Re: Framing Item
Location: Lot 11 Cotton Farms (240 Deer Tail Lane Fuquay-Varina, NC)
JDS Project No.: RDU2309722
Date of Inspection: 10/13/2023

A representative of JDS Consulting arrived on site to observe the issues reported to us by the client, which are presented, along with our recommendations, in this report.

ROOF STRUCTURAL PLAN

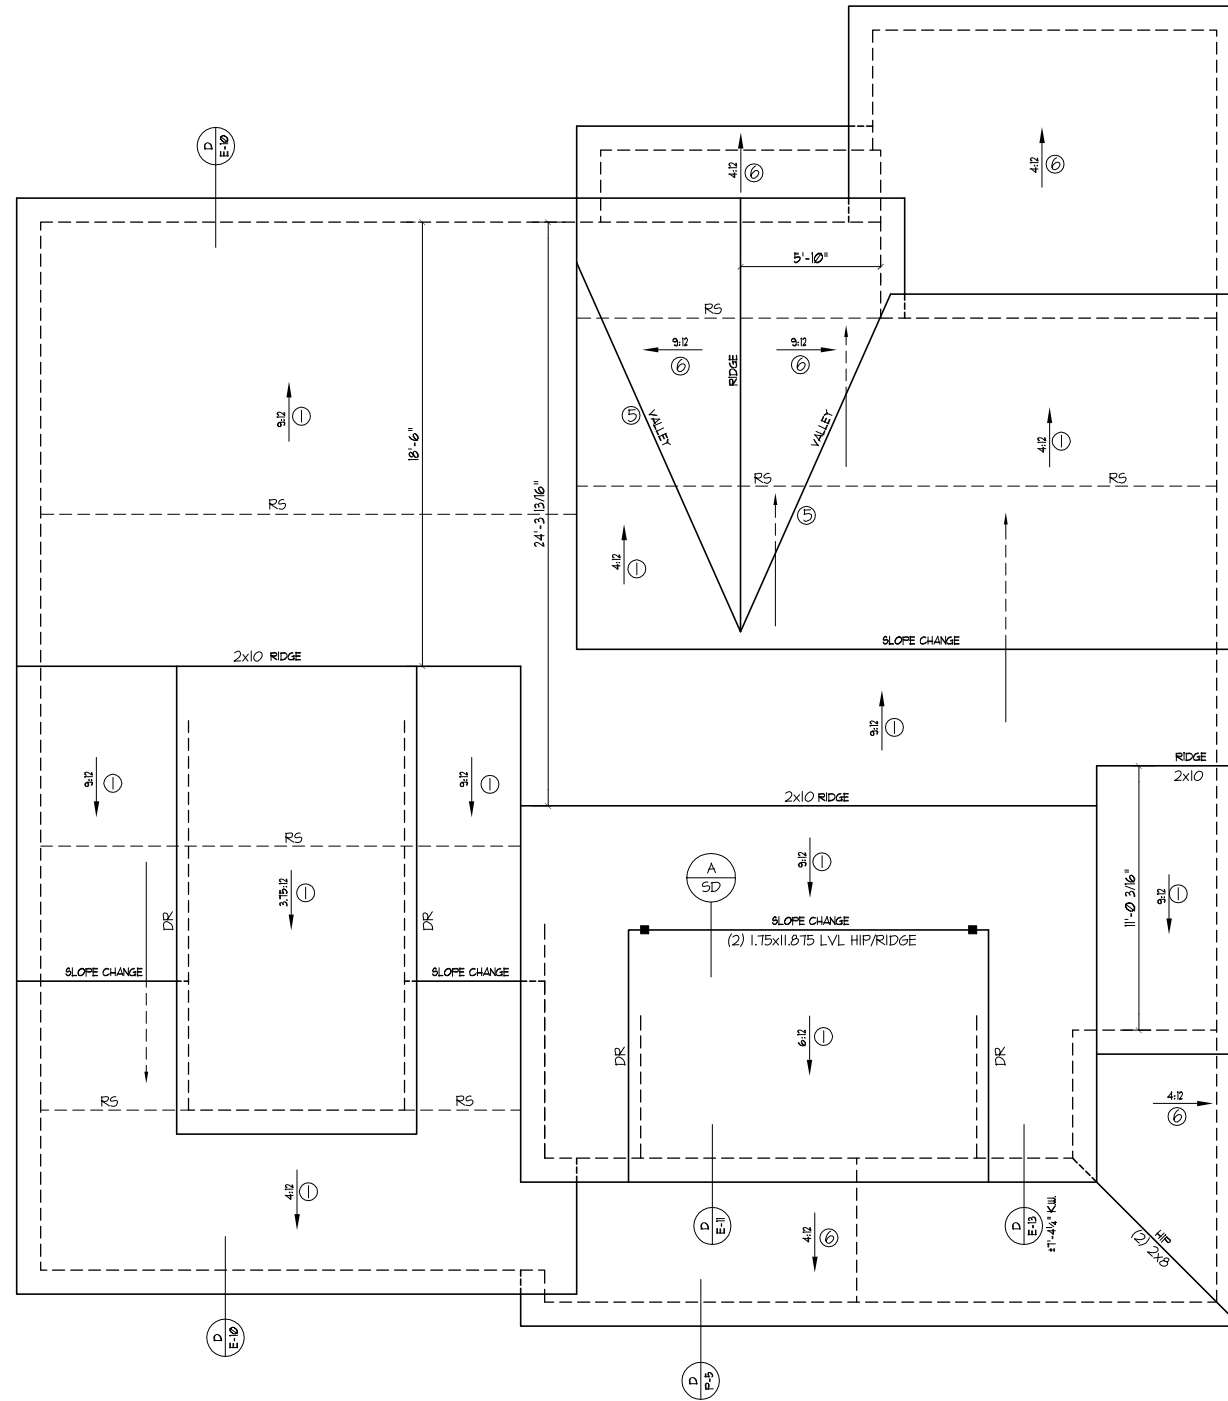
The client requested an evaluation of the 1st -3rd 2x8 rafter from the left bedroom wall, for the 2nd and 3rd, the contractor installed (1) 2x8 approximately 5'0" long scabbed at the left side to furred out the gap between the rafter and ridge.

Based on our on-site observation and review, for the 1st rafter from the left, install (1) 2x8 approximately 5'0" long scab on (1) side of the rafter providing full contact with the 2x10 ridge and attach it with (3) rows of 10d nails spaced 8" o.c. the contractor shall follow the same nail pattern on the other rafters repaired.
